City of Albuquerque

***RE: DOUBLE RAINBOW NO. 4, 8100 MENAUL BLVD. NE (H19-D68). ENGINEER'S
CERTIFICATION FOR CERTIFICATE OF OCCUPANCY APPROVAL.
ENGINEER'S STAMP DATED MARCH 6, 2000.***

RE: DOUBLE RAINBOW NO. 4, 8100 MENAUL BLVD. NE (H19-D68). GRADING AND DRAINAGE PLAN FOR BUILDING PERMIT APPROVAL. ENGINEER'S STAMP DATED SEPTEMBER 8, 1999.

Re: Site Plan submittal for building permit approval for Double Rainbow, 8001 Menaul Blvd. N.E.,
Sombra Del Monte Addition, Block 5, Lots 1 & 2 [H19/D068], Architect's Stamp not dated.

sheet title  
GRADING & DRAINAGE PLAN

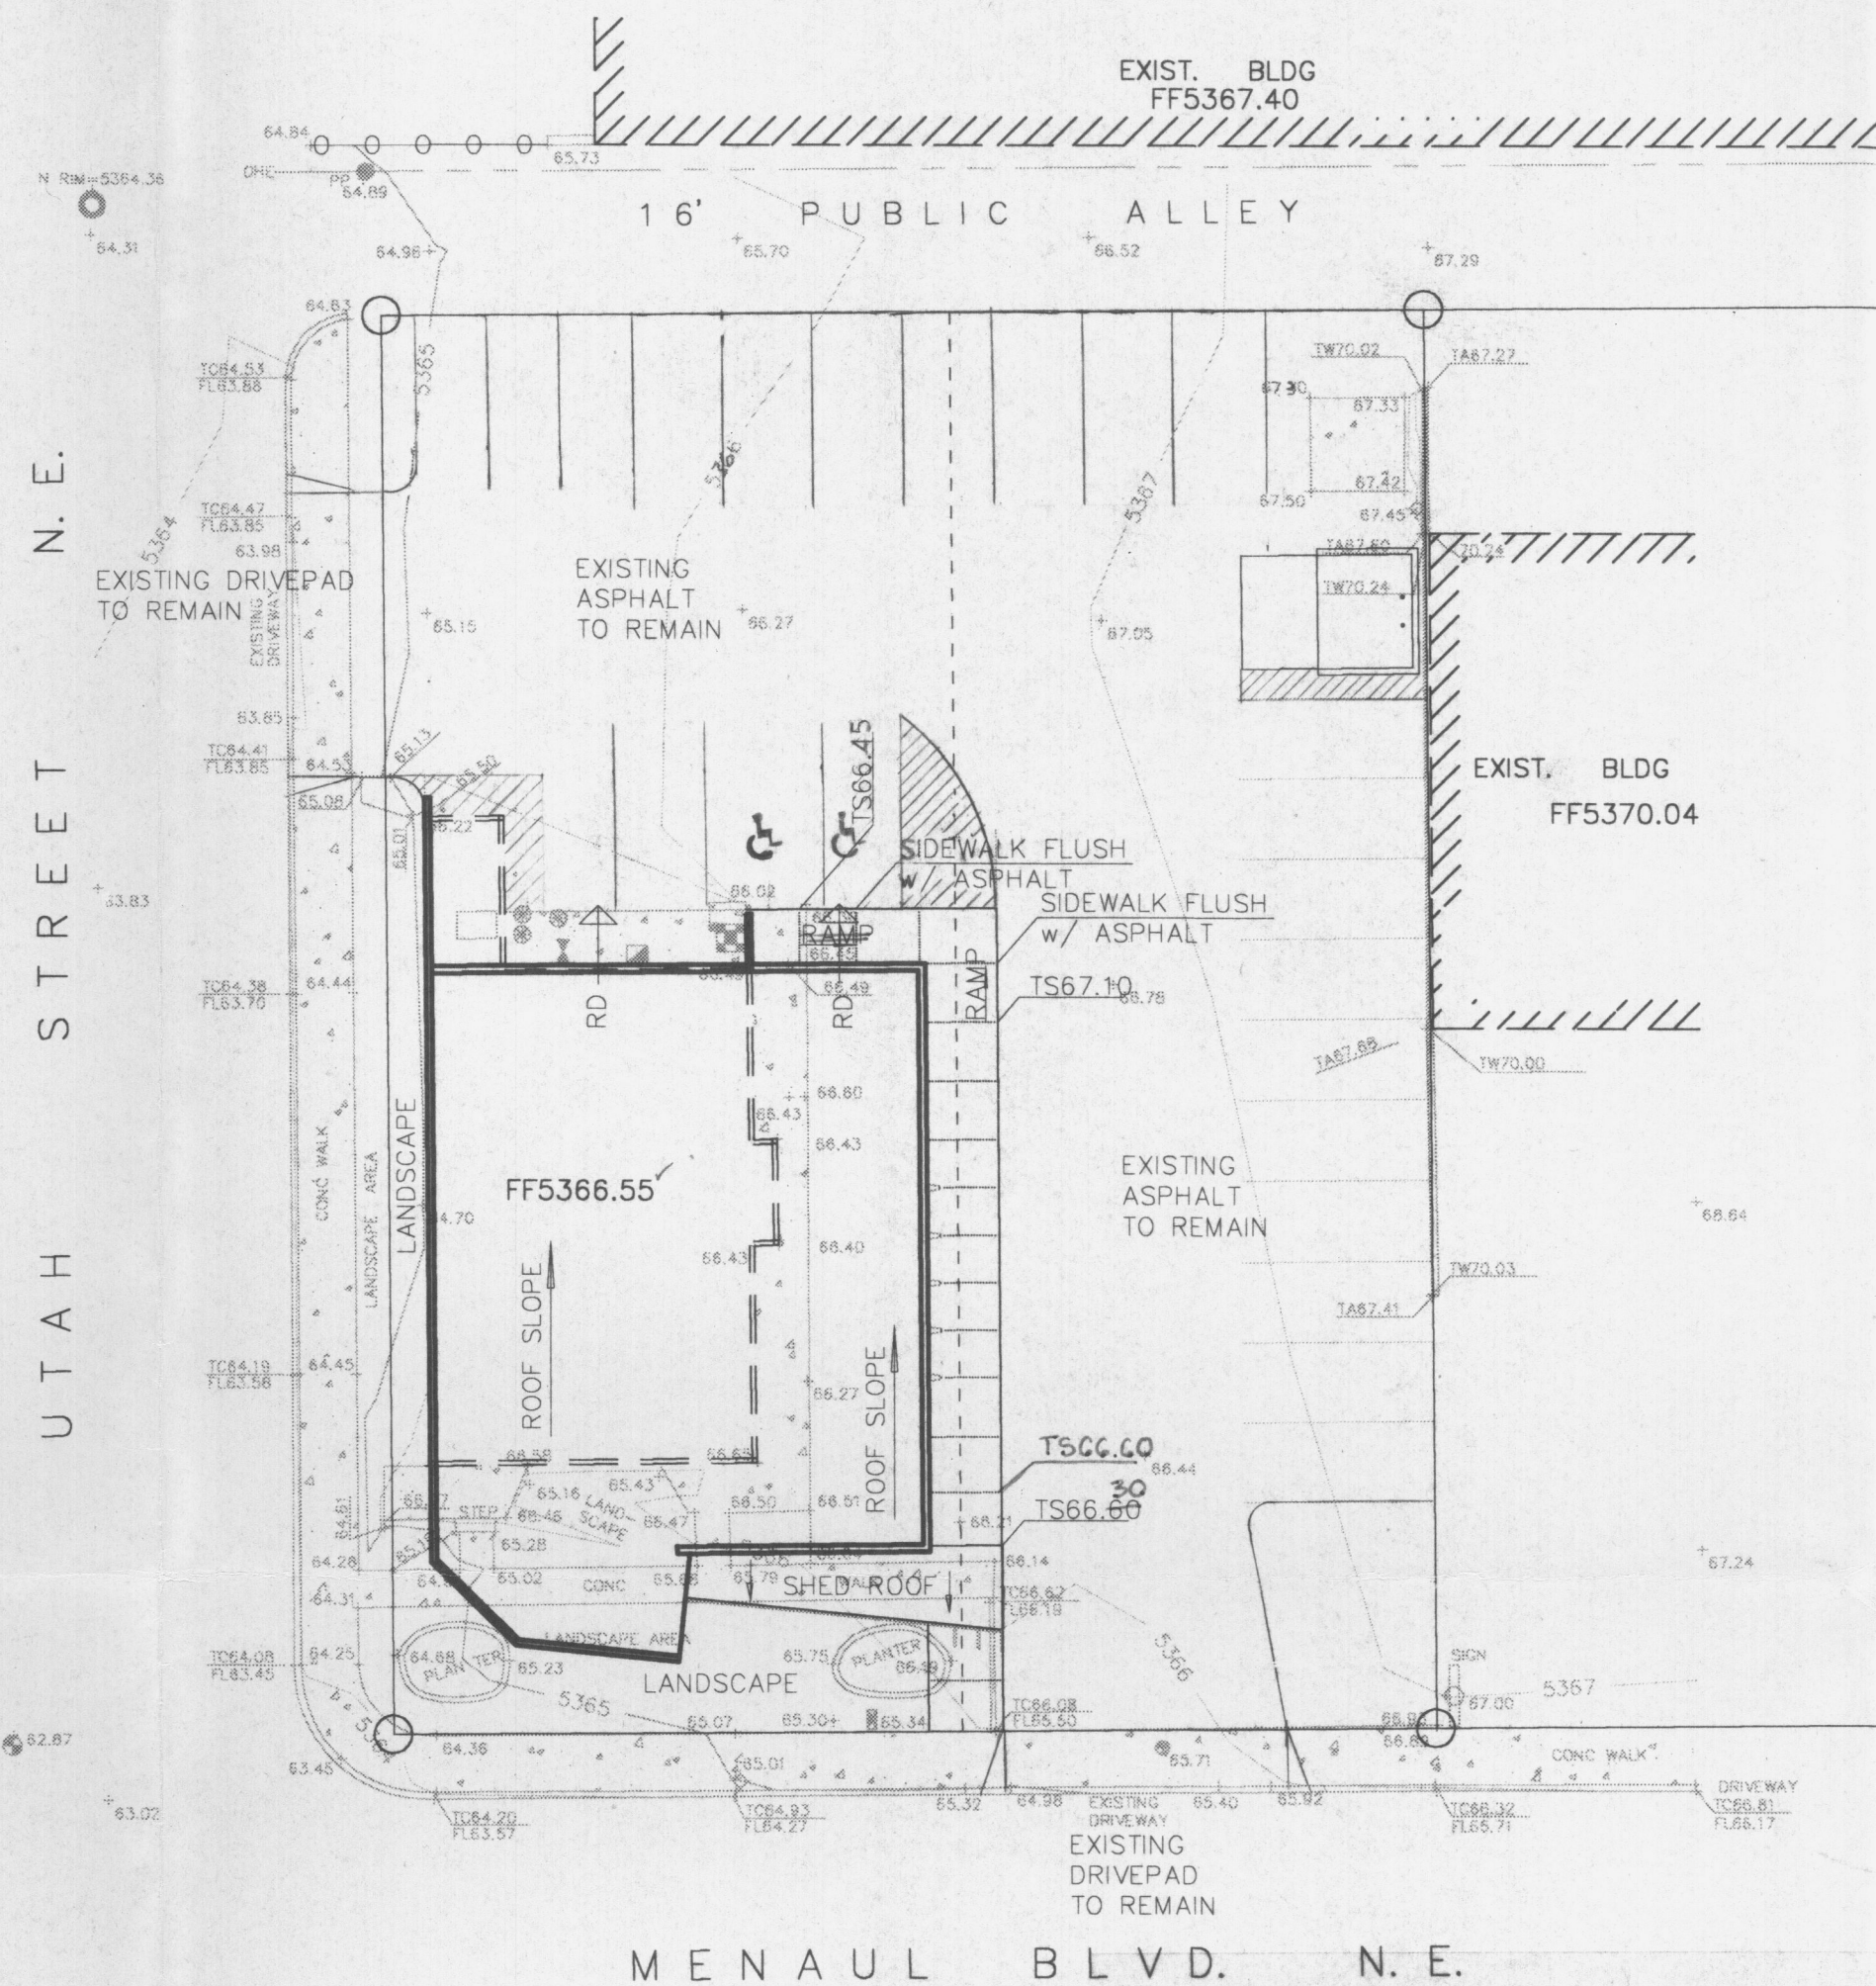
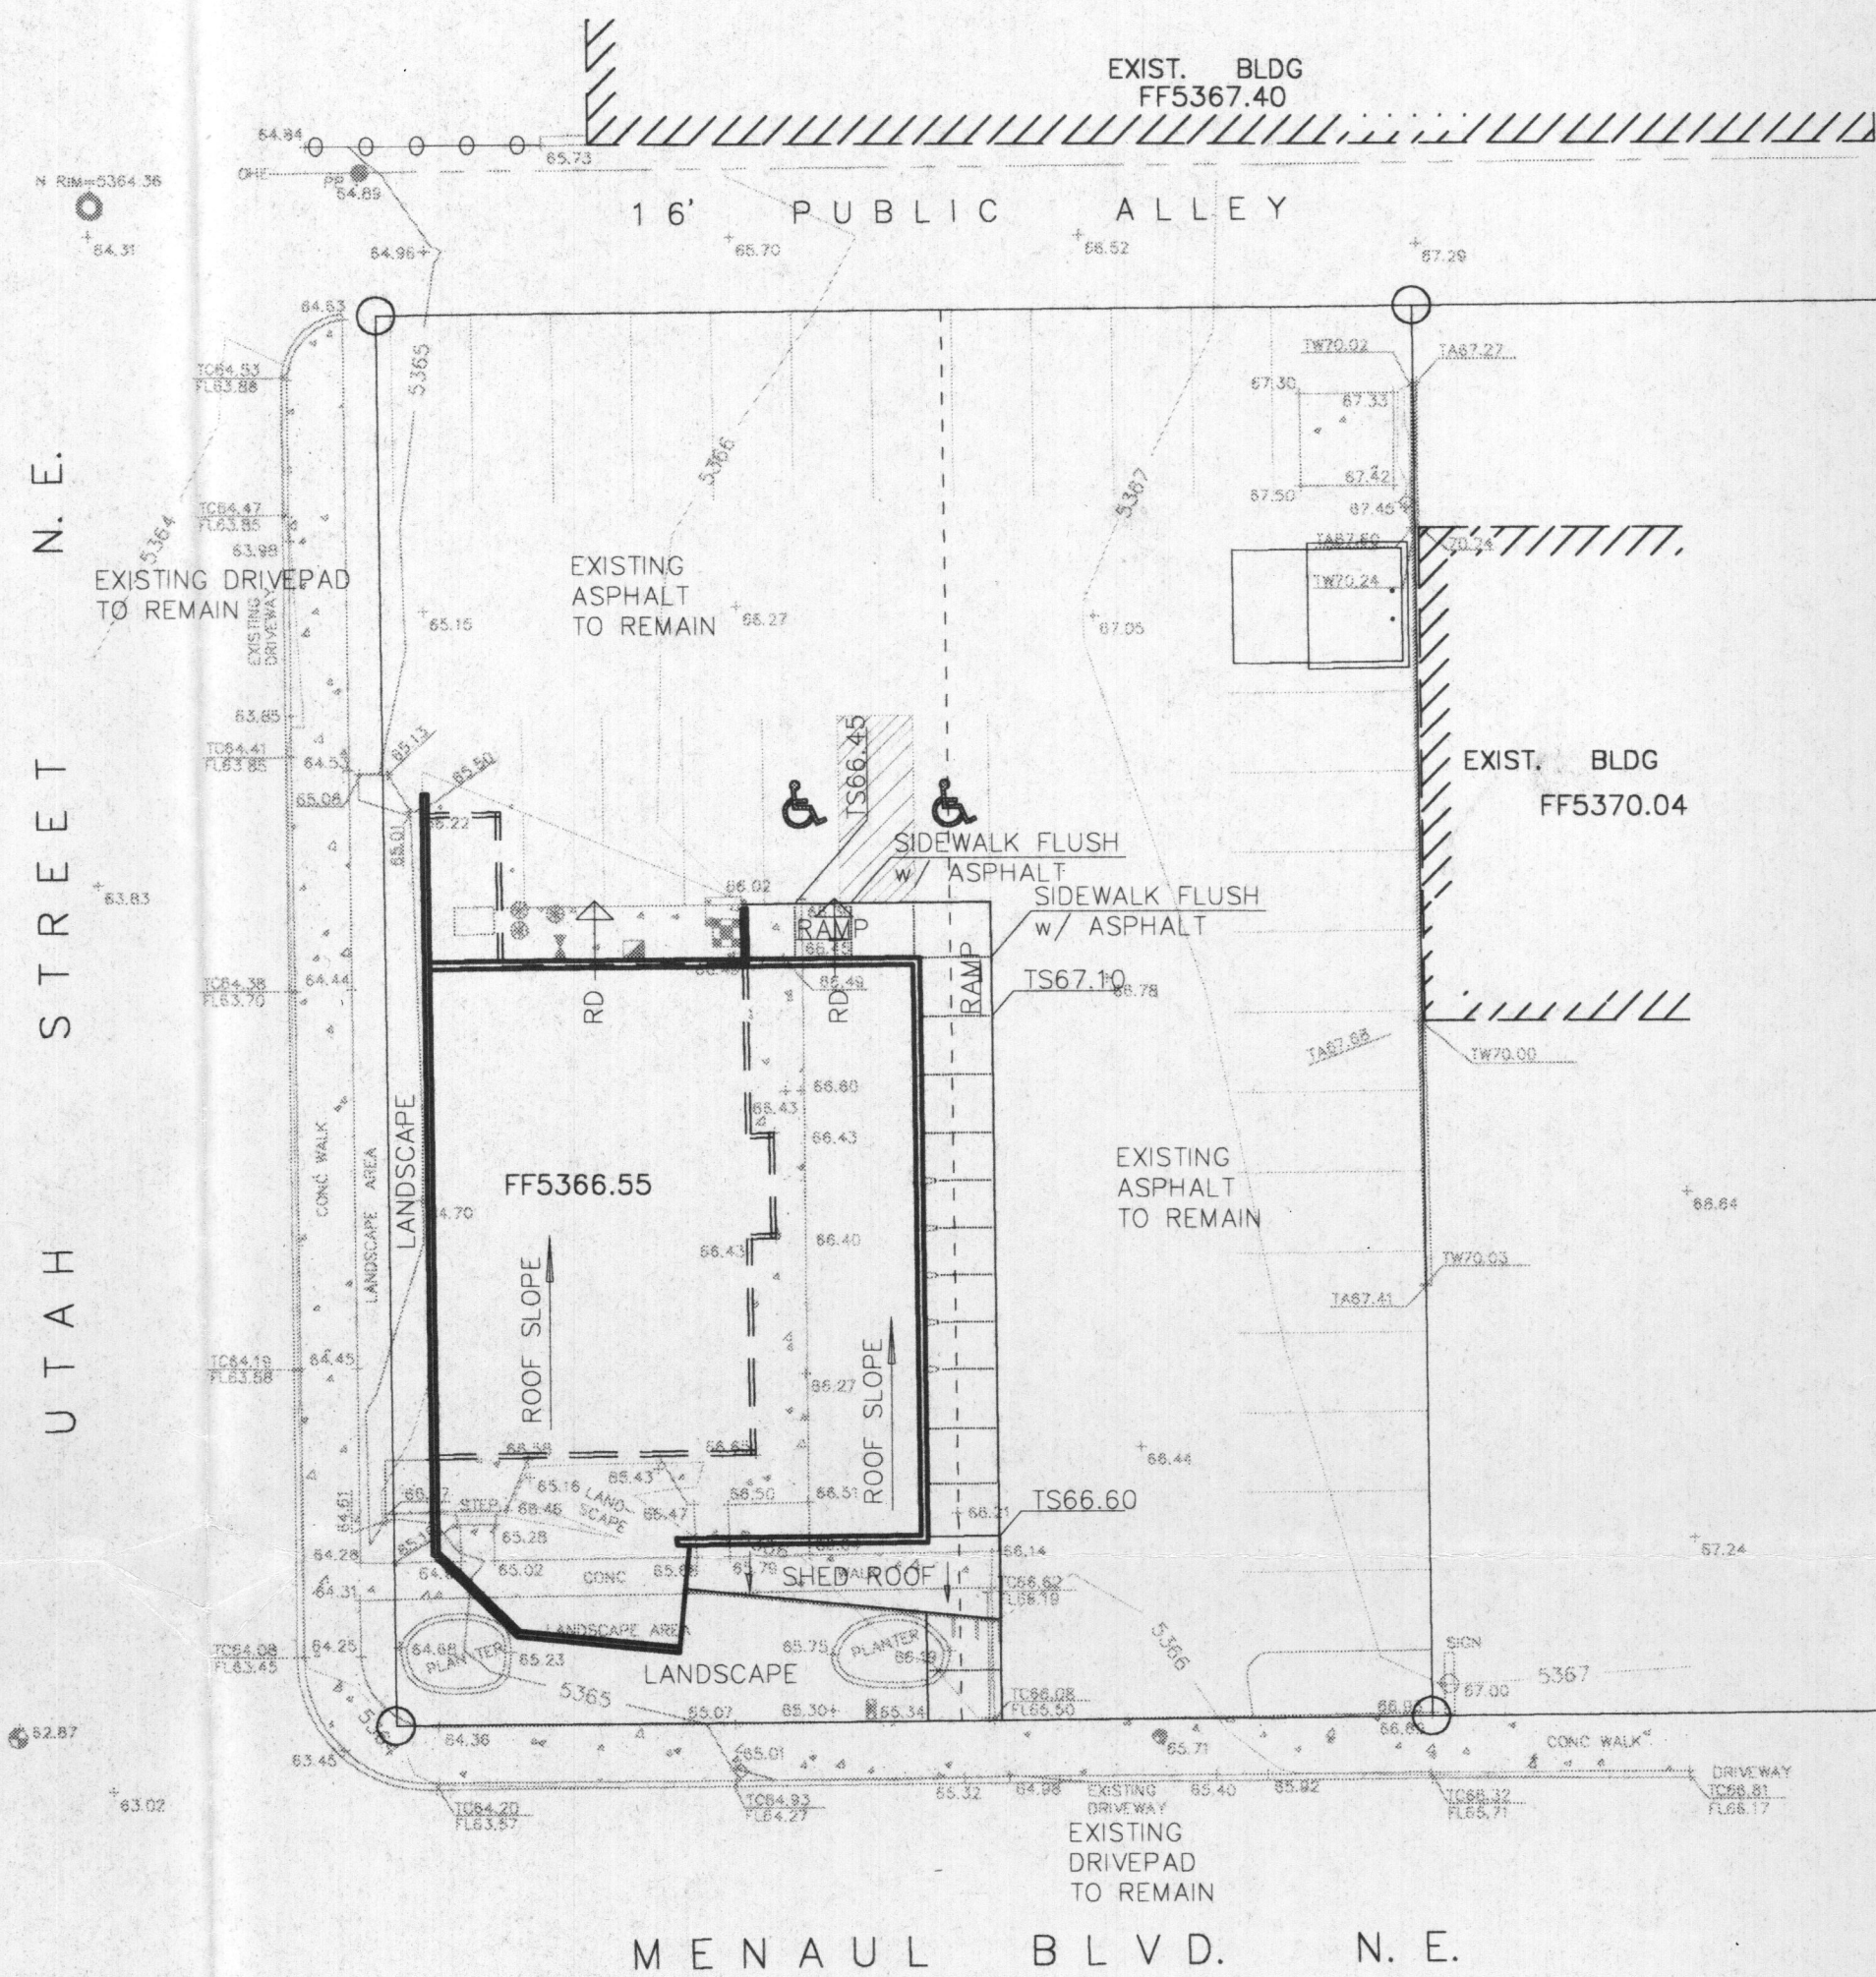
Note that the T.C.L. also needs to be certified.
